Rushes Creek Poultry Production Farm (SSD-7704-MOD-3)

Thank you for your email notification dated 18 January 2022 requesting WaterNSW's advice in relation to the Rushes Creek Mod-3 and providing the Rushes Creek SSD 7704 Mod 3 Modification Report, prepared by EME Advisory and dated January 2022.

WaterNSW has reviewed the Modification Report, and makes the following comments:

Figure 4 | Approved and Proposed Layout for Farm 2

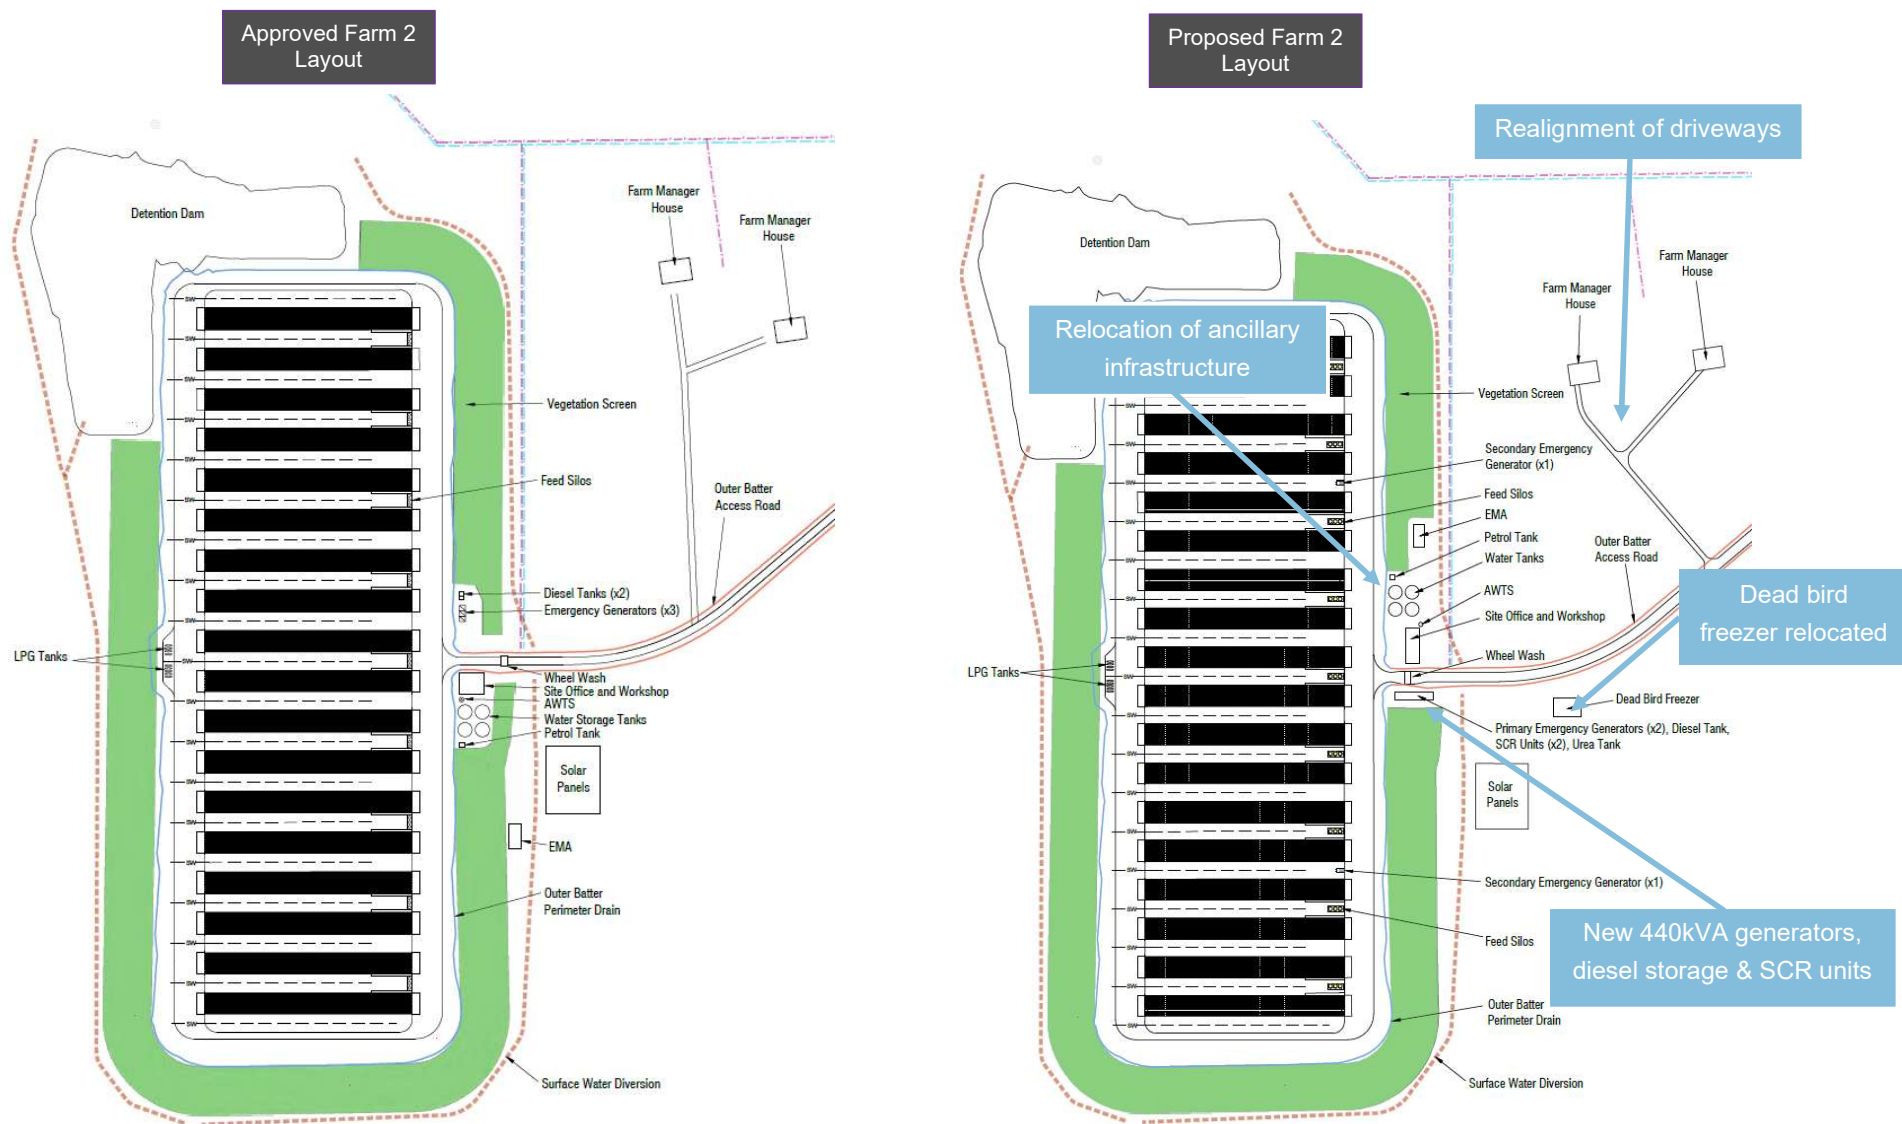
- WaterNSW notes the Modification proposes an additional 45 kVA emergency standby diesel generator and 2,000 litre bunded diesel storage tank at the water supply pump near the Namoi River to 'provide backup for the rare occasion when the primary operational power supply is lost'. However, the generator is also proposed to be used for 'up to 10 months' while a 'potential alternative renewable power option is finalised' and approved (p.22).

The Report (p.19) states that the generator and storage tank would potentially be located only 40 metres from the banks of the Namoi River, with the short flow path to the river and impoundment considered to increase the risk of impacts to water quality from potential spills or during flooding. As such, WaterNSW does not support diesel storage at this location and notes that with the site permanently occupied by farm managers, refuelling of the generator is possible using diesel delivered to and stored at Farm 2 instead, appropriately sited and bunded to 110% capacity.

- WaterNSW agrees that the proposed modifications to the layout of ancillary facilities and location of additional diesel generators at Farm 2 are unlikely to have any material impact on surface water quality. Notwithstanding, bunding of the relocated dead bird freezer should be considered, as it is outside the diversion swale and therefore any contaminated runoff occurring in the event of power loss and thawing of contents would not be collected in the detention dam.
